Planning Application Ref: Y/91/17/OUT

Location: Land at Bilsham Road, Yapton

Description of works: Outline application for the development of up to 250 residential dwellings (Class C3) vehicular access, public open space, ancillary works and associated infrastructure. Departure from the Development Plan

Tree Officer / Parks and Greenspace Team

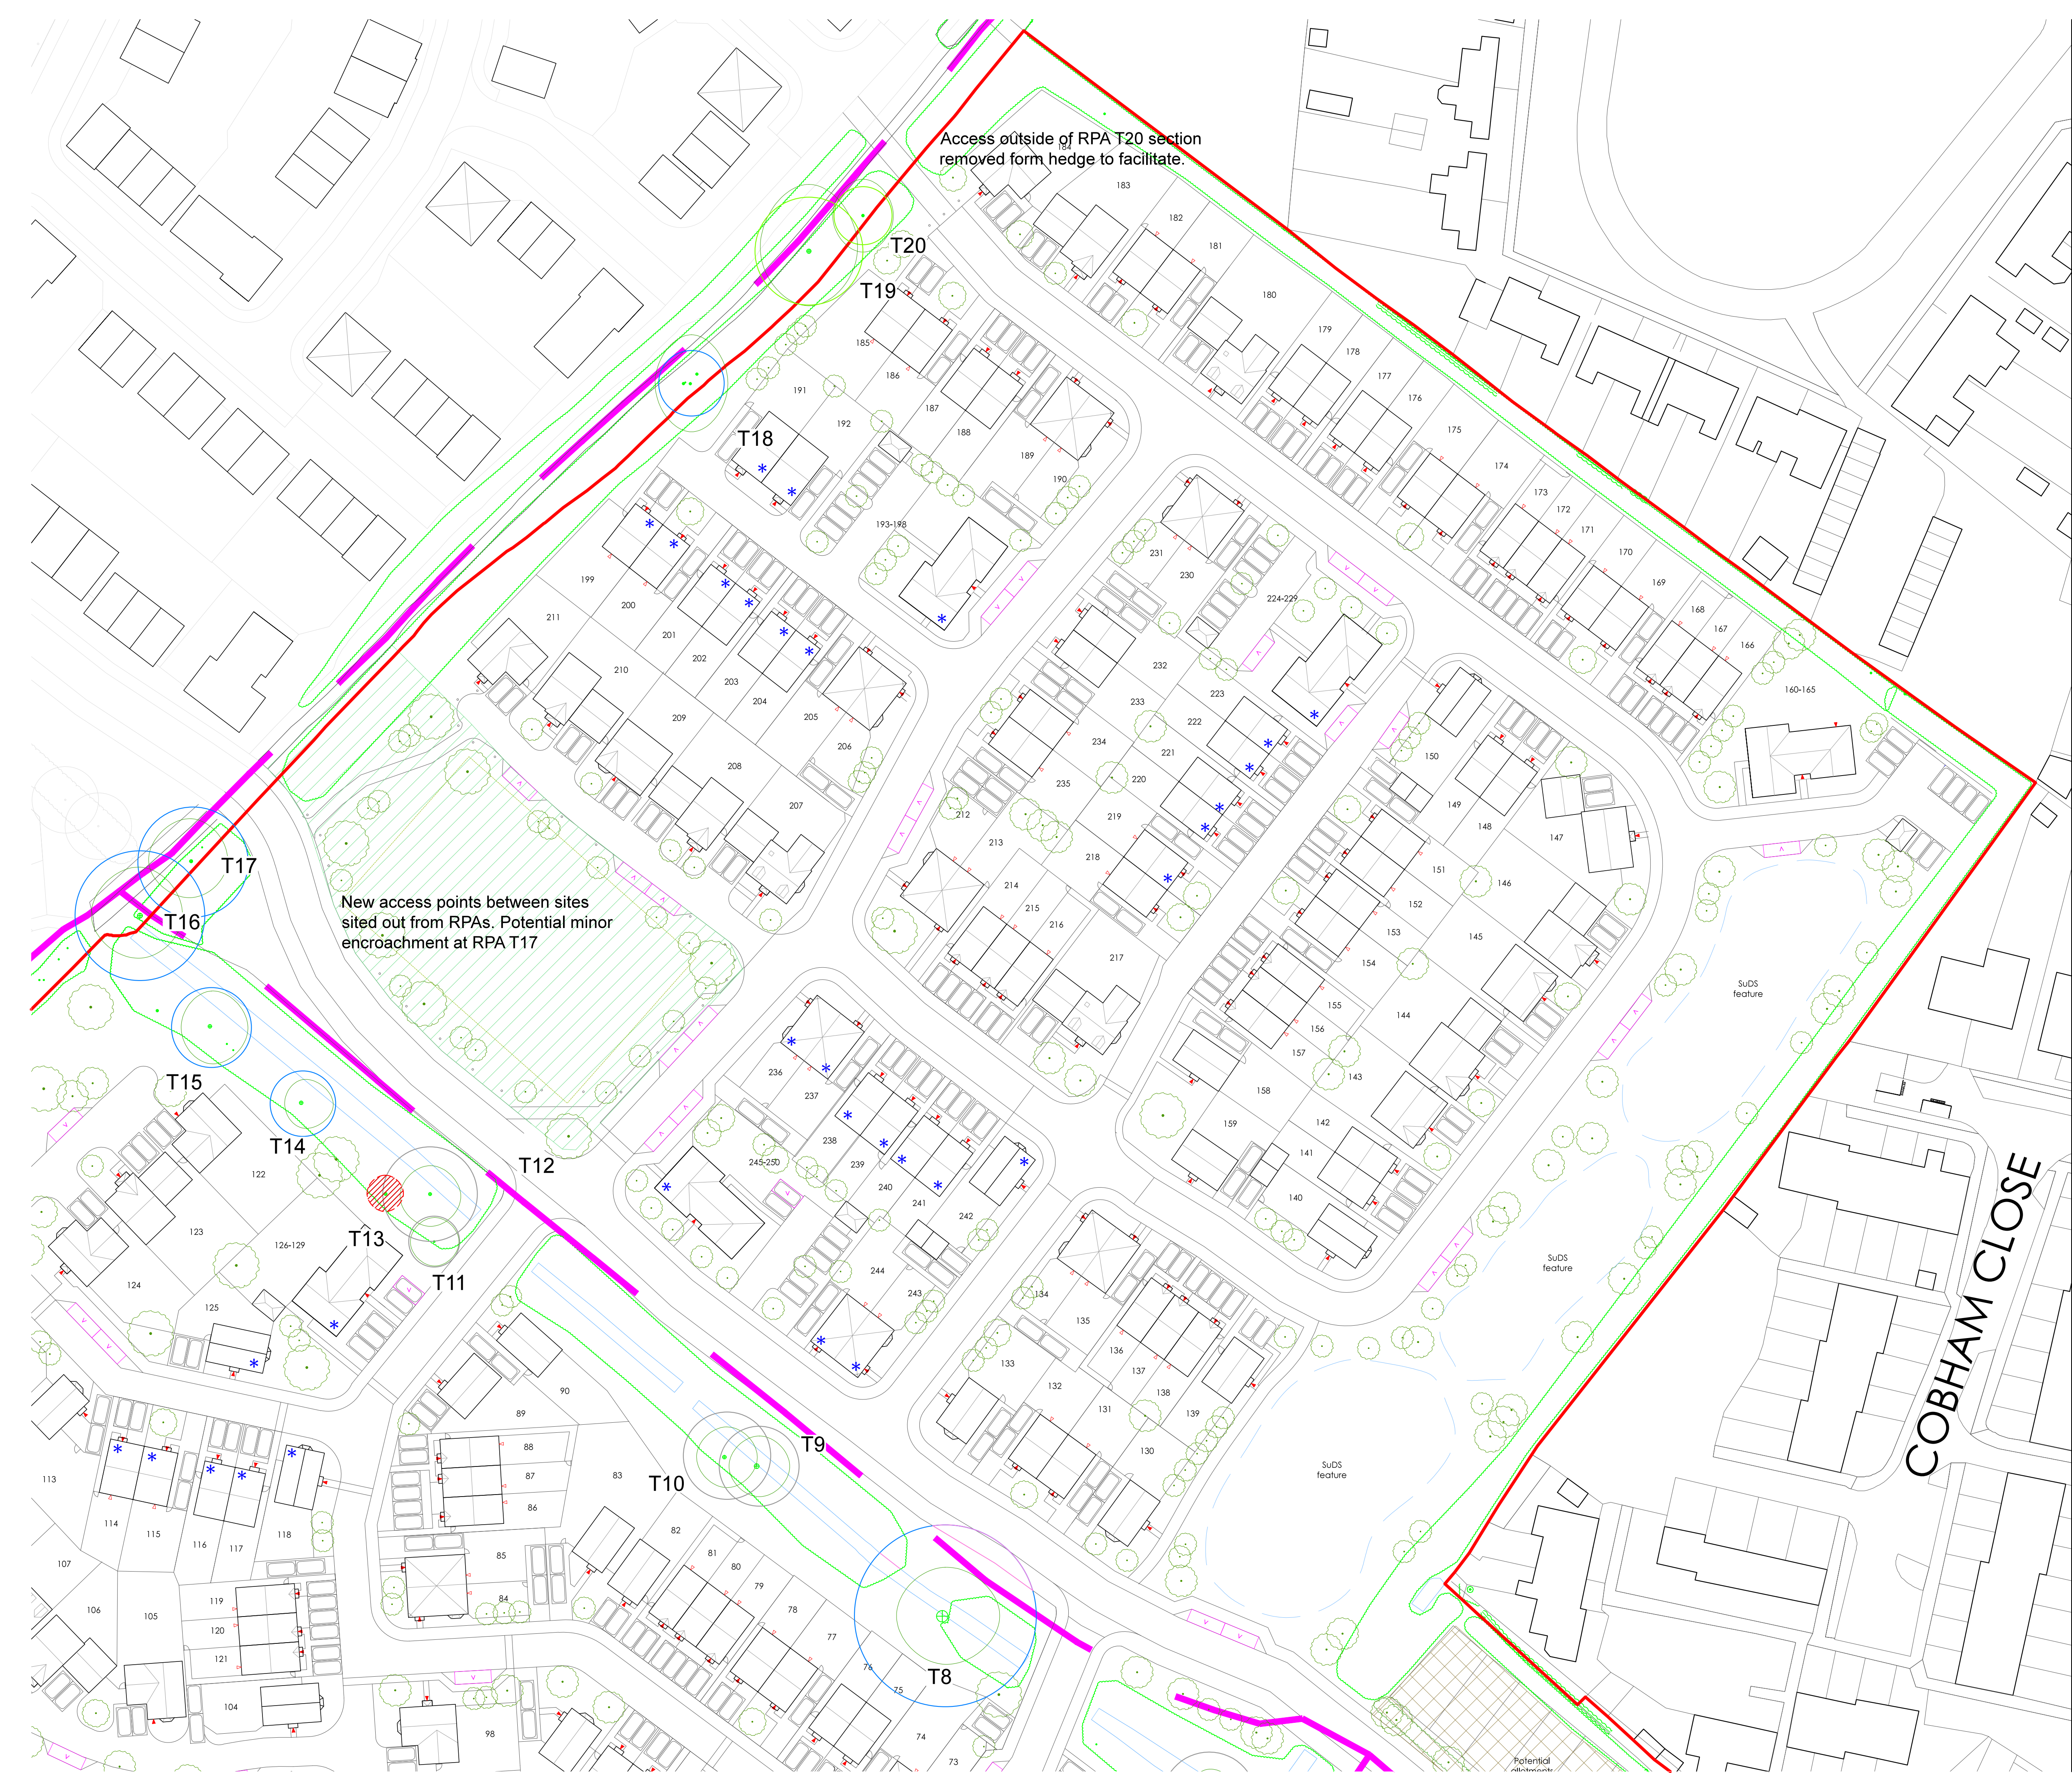
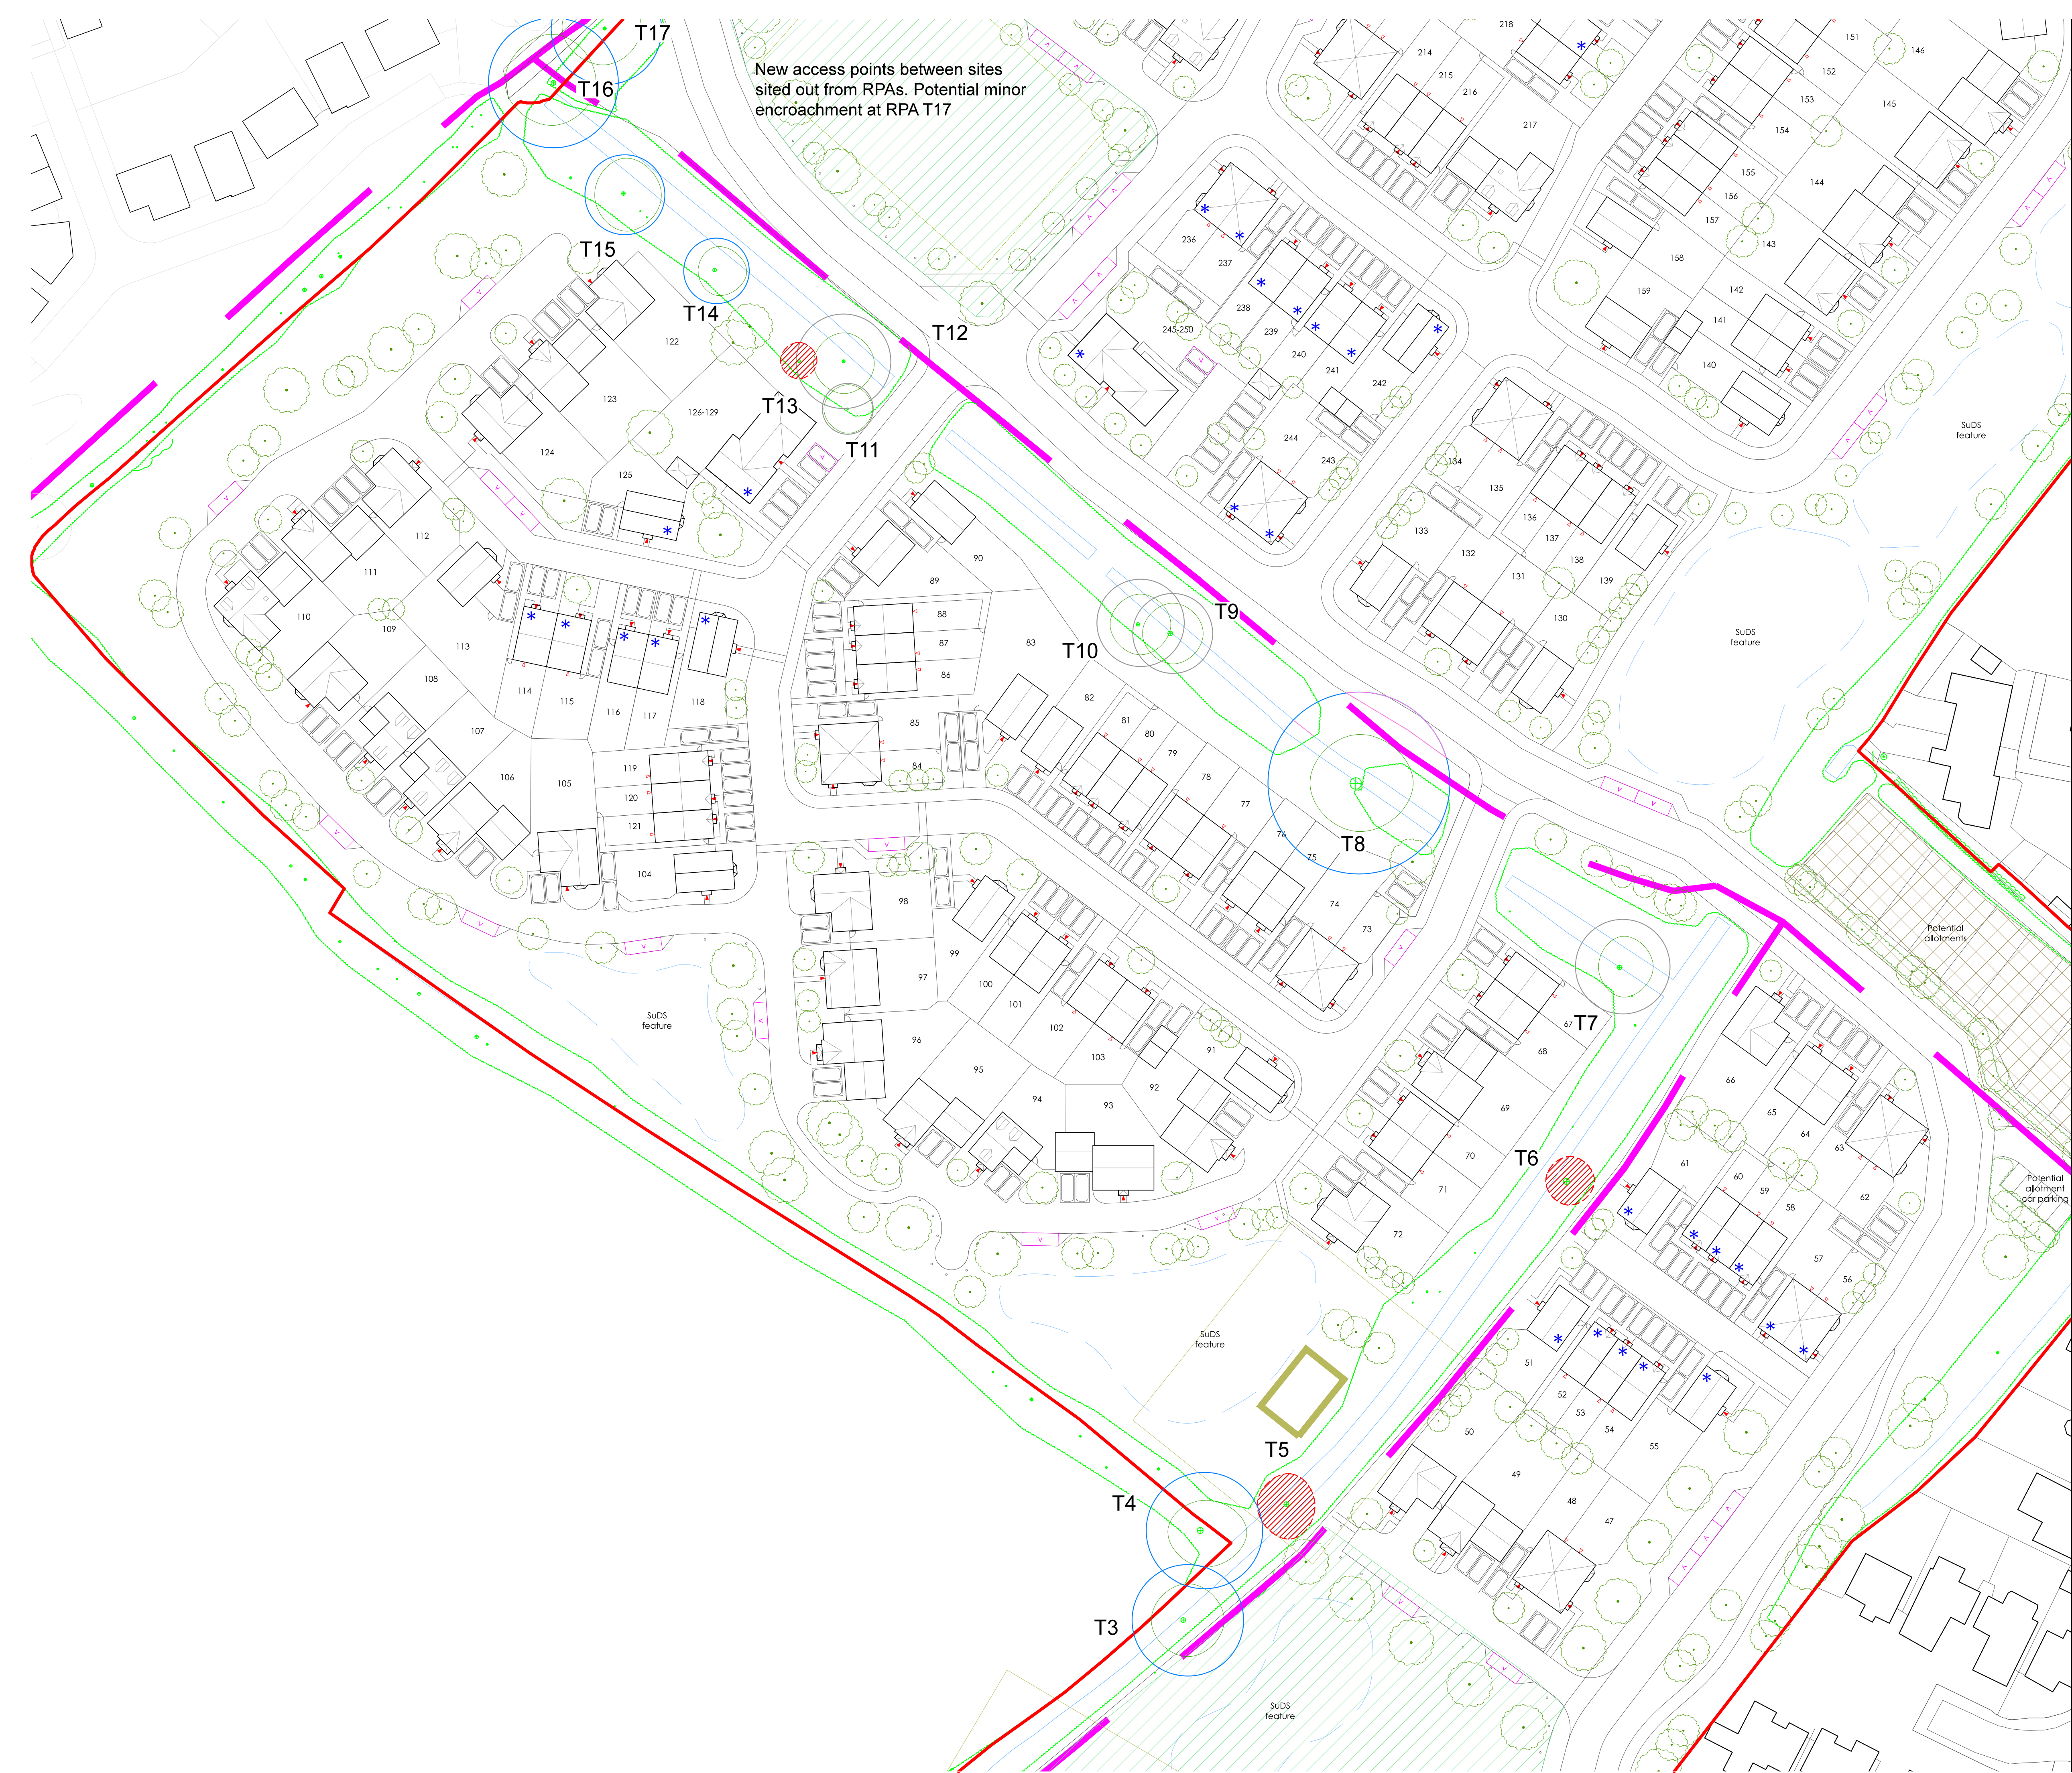
- The applicants employed the PJC Consultancy back in November 2017 to undertake a tree survey and then prepare an Arboricultural Impact Assessment (AIA) PJC/4699/17-02 R2. Tree Survey data is adequate at this stage and broadly accords with the requirements of BS5837:2012. I have referred to Illustrative detailed masterplan drg. 1244G.03 to assist with determining the accuracy of the Tree Constraints and Tree Retention Plans submitted by PJC with their AIA report. This allows me to gain a general understanding of how the plot layout and access routes relate to trees but is not specific enough for me to have full confidence they will be adequately respected and protected. PJC Consultancy have submitted a revised Arboricultural Survey and AIA, ref. nos 3867/15/01 & /02 - Rev 04 and dated 13th and 14th March 2018 respectively. I have been asked to consider the amendments and provide comment. The supporting text within suggests a well-intentioned plan for significant trees on the site although it lacks the necessary detail to ensure their adequate protection and respect once development is underway.

- I am pleased to see there is intent to retain the vast majority of recorded trees in harmony with the development, but I cannot be satisfied that this will be achievable until we receive a Tree Protection Plan (TPP) overlaying the final proposed site design layout, with supporting Arboricultural Method Statement (AMS) where RPA (Root protection area) incursion is anticipated - which I would expect to see submitted with a subsequent full planning application.

- At this outline stage, the indicative layout and access arrangements and the appointed arboriculturalist's general regard for significant trees existing on site are encouraging and I am in broad agreement with their survey information. That said, I am concerned that there appear to be notable omissions in respect of existing tree cover along several sections of the site perimeter (South, adjacent arable farmland – East, rear of The Millers – North, south of dwellings at Tack Lee Road). This may be deliberate as the proposed design does not at this stage suggest any direct interference with them but it is important to consider all trees whether they are on or off-site and within potential influencing distance, so as to inform the site layout design which may of course be subject to revision. Any omissions will need to be addressed and therefore included in the aforementioned TPP and AMS should this proceed to a full planning application. Despite appearing in symbolic form on the Illustrative detailed masterplan drg. 1244G.03, significant trees located within the Southern site perimeter hedgerow were omitted from the tree survey schedule provided by PJC. They are of such dimensions and proximity as to be a material consideration and will require full consideration and appropriate levels of protection before any work can commence on site. I have determined that the majority of these merit a TPO. These trees have now been included in the tree survey schedule and so should be recognised in the anticipated TPP.
